## **CBD and South East Light Rail (SSI 6042) Modification 4 Submission from Randwick City Council**

### **1.0 Introduction**

Figure 3.2: Plan of the revised UNSW High Street stop arrangement

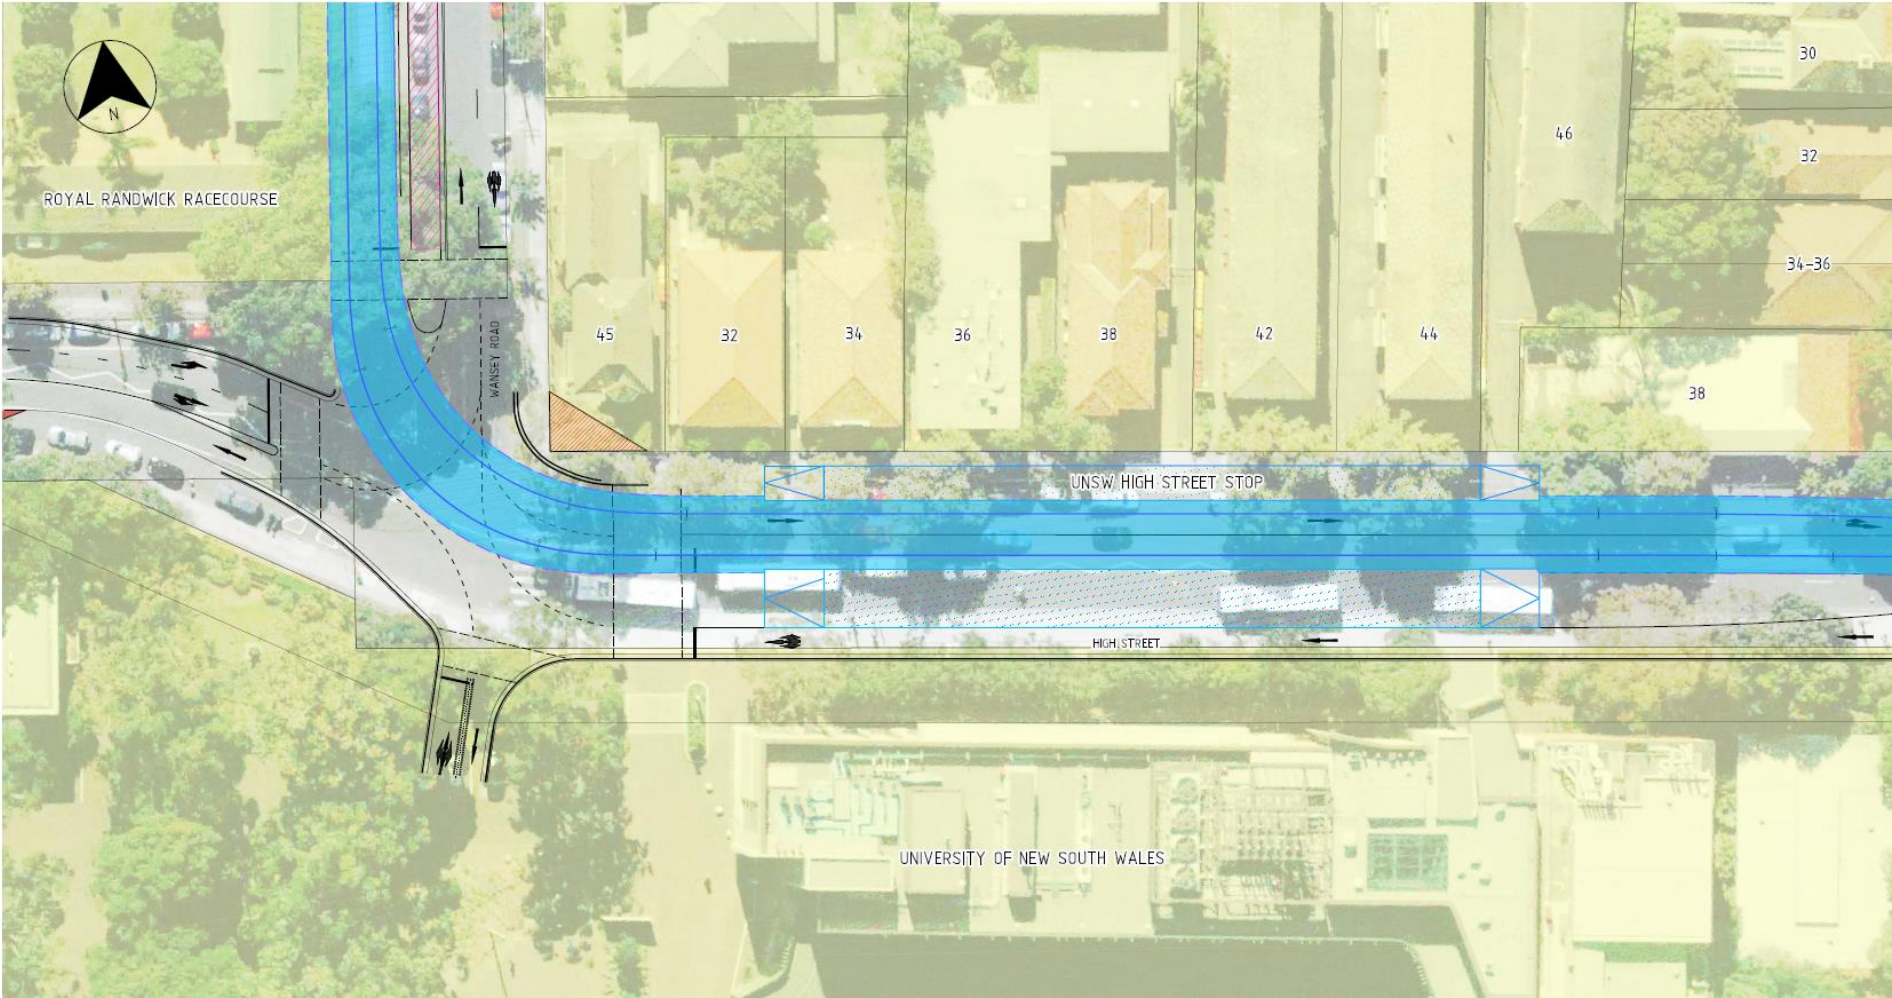
- Council notes the minor changes in visual and landscape character impacts at the UNSW High Street stop – however considers that the improved footpath capacity and retention of the row of existing trees fronting UNSW is an improvement in streetscape amenity and visual character compared to the approved design.
- There is inconsistency throughout the report in relation to the existing trees along the northern and southern footpaths of this stop. The report does not mention any impacts to these trees, it is noted that figures 3.5 and 3.6 on page 13 show that the trees along the northern footpath are being removed and the ones in front of the Lowy Cancer Centre are being replanted following construction. This can also be seen in the photomontage illustration of the stop Figure 3.7 on page 14.

Council does not support removal of the row of existing trees fronting the Lowy

Cancer Centre. This modified design reduces the extent of encroachment of the light rail alignment into UNSW land, and a key driver and benefit of this modification is the improved public domain outcome and retention of this row of trees. Council is concerned about the realistic success of re-planting the existing trees following construction, and seeks their protection and retention.

13	<p>UNSW High Street stop:</p> <p>Council notes the minor changes in visual and landscape character impacts at the UNSW High Street stop – however considers that the improved footpath capacity and opportunity to retain the row of existing trees fronting the Lowy Cancer Centre is an improvement in streetscape amenity and visual character compared to the approved design. Council requests confirmation that the trees in front of the Lowy Cancer Centre will be protected and retained.</p> <p>Request for the undergrounding of power and for the integration of stop columns/</p>

Figure 2: Proposed alternative access for affected High Street properties (Source: TfNSW, 2016)

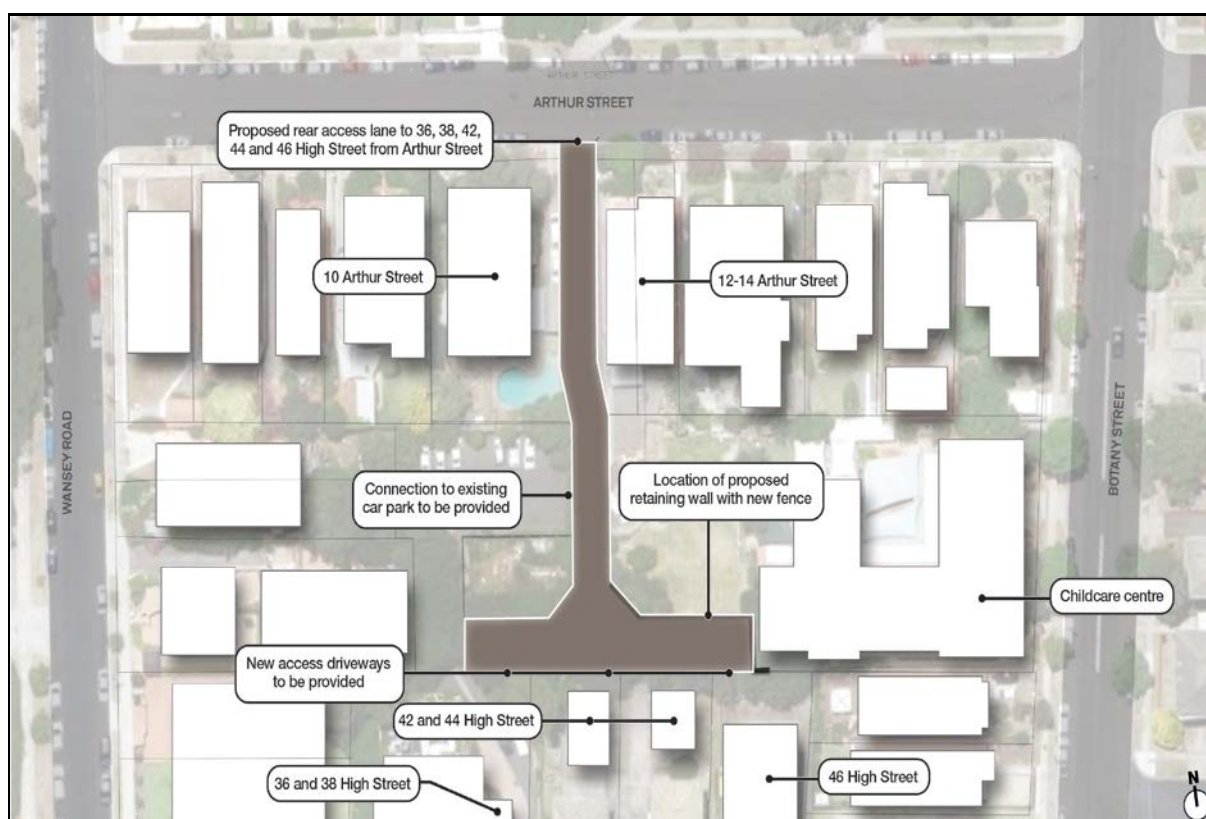
- While noting the increased visual impact of the new lane off Arthur St, the impact from the public domain is considered minor, and reasonable in the context of the benefits provided.
- Minor visual impacts during the construction of the new laneway to provide access to properties fronting High Street and Botany Street with some minor visual impacts in relation to the removal of 12 trees at the back of the properties for the construction of the new laneway.

- Council notes that there are some impacts with the proposed removal of 12 trees at the back of the properties fronting High Street and Botany Street for the construction of the new laneway.

Council acknowledges that the design of the new laneway is indicative at this stage, and in principle supports the intended construction of the laneway as a public road. In order to meet the design and operational requirements of a public road, further discussion and consultation with Council during detailed design stage is sought. These requirements include, for example, design vehicle definition and loading conditions, key dimensions to suit access, safety and servicing needs, landscaping opportunities, tree planting, drainage, utilities, signage and the like.

22	<p>New Laneway:</p> <p>While supporting the intended public laneway, consideration should be given during detailed design stage to ensure the lane is not perceived or used as a public thoroughfare (ie: no access to High Street), and incorporate CPTED principles. Opportunities to provide a positive visual impact are also encouraged, as indicated in section 3.2.</p>
23	<p>Laneway design standards:</p> <p>Council requests an additional Condition of Approval requiring consultation with Council on the detailed design of the laneway, and compliance with relevant design, construction and operational standards for a public road. It is considered that the design of the laneway needs further resolution in order to inform boundary changes and subdivision plans.</p>

Figure 5: Approved (left) and Revised High Cross Park compound and substation location (right)
(Source: TfNSW, 2016)

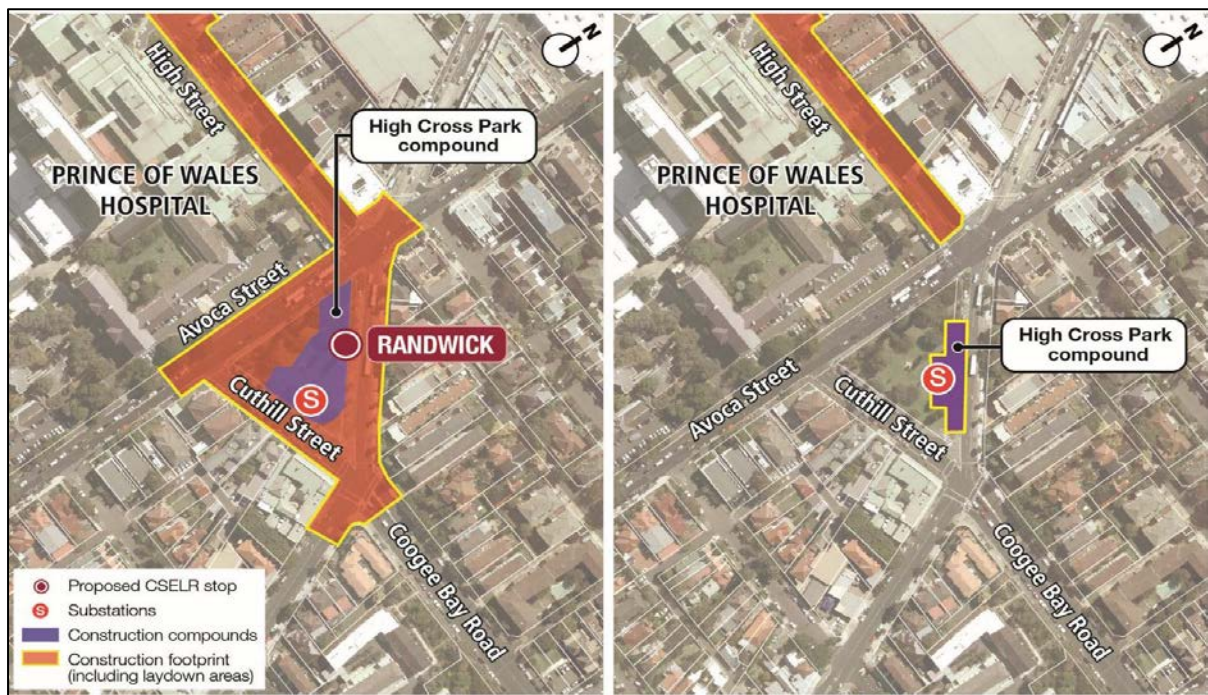
- Council strongly supports the retention and preservation of High Cross Park and the undergrounding of substation. This should be done sensitively to minimise the impact to open space, trees and heritage values.
- Council notes that there will be some minor visual impact to High Cross Park with the removal of 7 trees along the edge of Belmore Road for the construction of the underground substation. Council requests consideration of transplanting these trees to an alternative location.
- The report does not define the above and below ground infrastructure that will be required for the operation and maintenance of the underground substation and the visual impacts that these might have on the park/public domain.

- Council notes that there will be some minor impacts to High Cross Park with the removal of 7 trees along the edge of Belmore Road for the construction of the underground substation.
- Council notes that there will be constraints in relation to the provision of trees or landscaped areas in the area above the substation and that there will need to be consideration at the design stage for the provision and integration of these as part of the final design for this section of the park.

10	<p>High Cross Park:</p> <p>Request that detailed design ensures minimisation of impact to High Cross Park from excavation for the substation and maximise retention of soft landscaped area, including consideration of the opportunity to overlay the excavation/ construction footprint with a lane of Belmore Road and adjacent footpath.</p> <p>Request that design consideration is given to the underground and above ground infrastructure that will be required for the operation and maintenance of the underground substation and how this infrastructure will impact the usage and visual amenity of the park. In particular it is requested that vents and access ways for the substation are placed to avoid impact on soft landscaped areas.</p> <p>Request that the design for the reinstatement of the park at the underground substation location is developed in consultation with Council, and includes opportunities for sitting, gathering and retention of the current passive usage of the</p>

<p>park.</p> <p>Request consideration of opportunities to transplant the 7 trees identified for removal in the Park.</p>
11	<p>Randwick Terminus:</p> <p>Request for the undergrounding of power and for the integration of stop columns/totems with the catenary poles.</p> <p>Design consideration should be given to the placement of street furniture along the southern footpath along the Randwick Terminus in relation to the footpath width reductions.</p> <p>Request that the detailed design allows for a seamless transition and coordination with the Hospital site public plaza at the corner of High St and Avoca St. The integrated design should be consistent with Council's Light Rail Urban Design Guidelines and developed in liaison with Council.</p>
12	<p>General – High Street Alignment:</p> <p>Illustrations of the revised stops on High Street indicate that overhead powerlines have been removed. Council strongly supports undergrounding of overhead powerlines along the High Street alignment, including at light rail stops.</p> <p>A holistic design approach to poles and wires to minimise visual clutter and provision of street trees is requested, including the undergrounding of power and the provision of multifunction poles that can cater for street lights, traffic lights, catenary wires, banners and hanging baskets for plants.</p> <p>Request for street furniture, paving and street tree species to be consistent with the Randwick City Council's Light Rail Urban Design Guidelines Volumes 1 &amp; 2.</p> <p>Request that detailed design consider where there are new opportunities for Integration of public art in the public domain.</p>

16	<p>High Cross Park:</p> <p>Council notes that there will be constraints in relation to the provision of trees or landscaped areas in the area above the substation and requests consideration at the detailed design stage for the provision and integration of these as part of the final design for this section of the park.</p> <p>Council requests consideration of the opportunity to transplant the 7 trees identified for removal in the Park.</p>
17	<p>Randwick Terminus:</p> <p>Request for street trees to be incorporated in the vicinity of the Randwick Terminus where possible.</p>
